Ribble Valley Borough Council
Council Offices
Church Walk,
Clitheroe
Lancashire
BB7 2RA

Phone: 0300 123 6780
Email: developeras@lancashire.gov.uk
Your ref: 3/2025/0002
Our ref: 3/2025/0002/HDC/KW
Date: 27 July 2026

Location: Land rear of Sabden Village Hall Wesley Street Sabden BB7 9EH
Proposal: Proposed car park for 12 spaces plus additional disabled parking space.
Grid Ref: 378091 437641

Ref: BTC3359-TPP

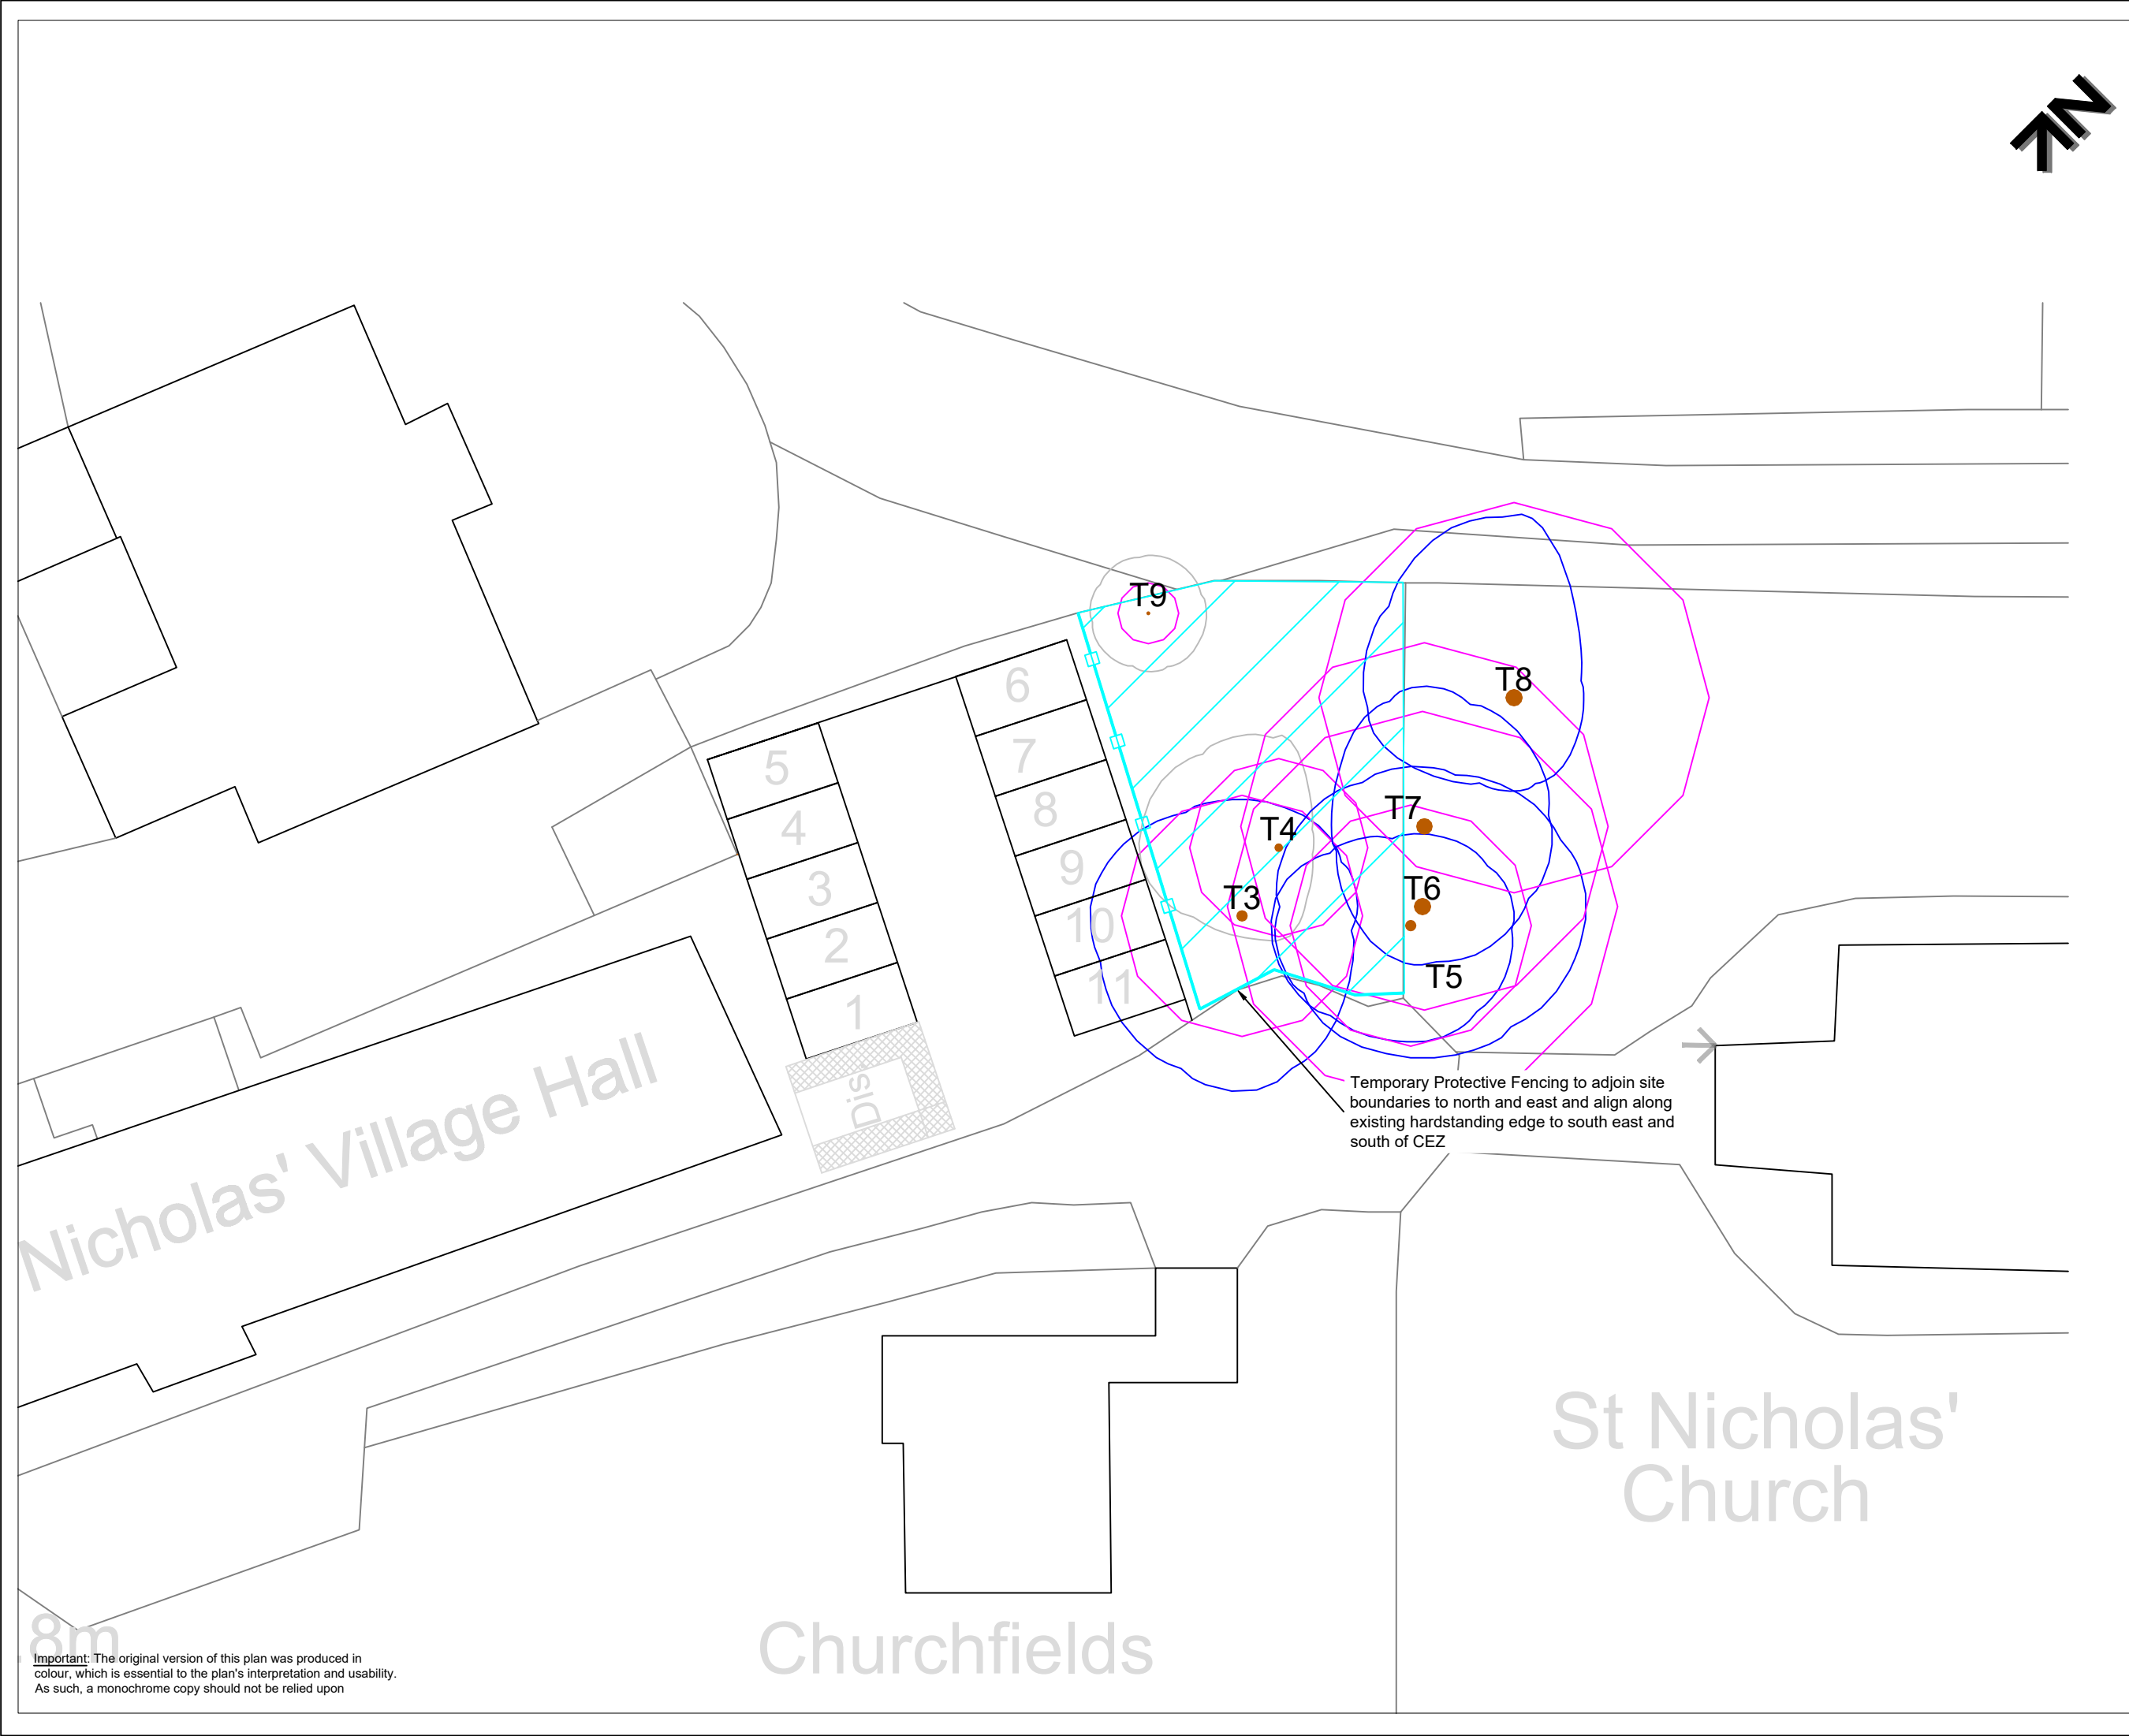
The LHA have reviewed the amended Proposed Site Plan, drawing BTC3359-TPP and are aware that the proposed car park will provide 11 standard parking bays which are 2.4m wide and 4.8m long.

A disabled bay has also been included within the proposed plan. The disabled bay meets the standard size, which is 2.4m x 4.8m with 1.2m clearance.

The centre of the car park is clear, providing unobstructed manoeuvring space into and out of the bays as well as turning, allowing vehicles to enter and exit the site in forward gear.

1. No use hereby permitted shall commence until the car parking area has been surfaced or paved in accordance with a scheme to be approved by the Local Planning Authority and the car parking spaces and manoeuvring areas marked out in accordance with the approved plan. The car parking area shall thereafter be kept free of obstruction and available for the parking cars at all times.
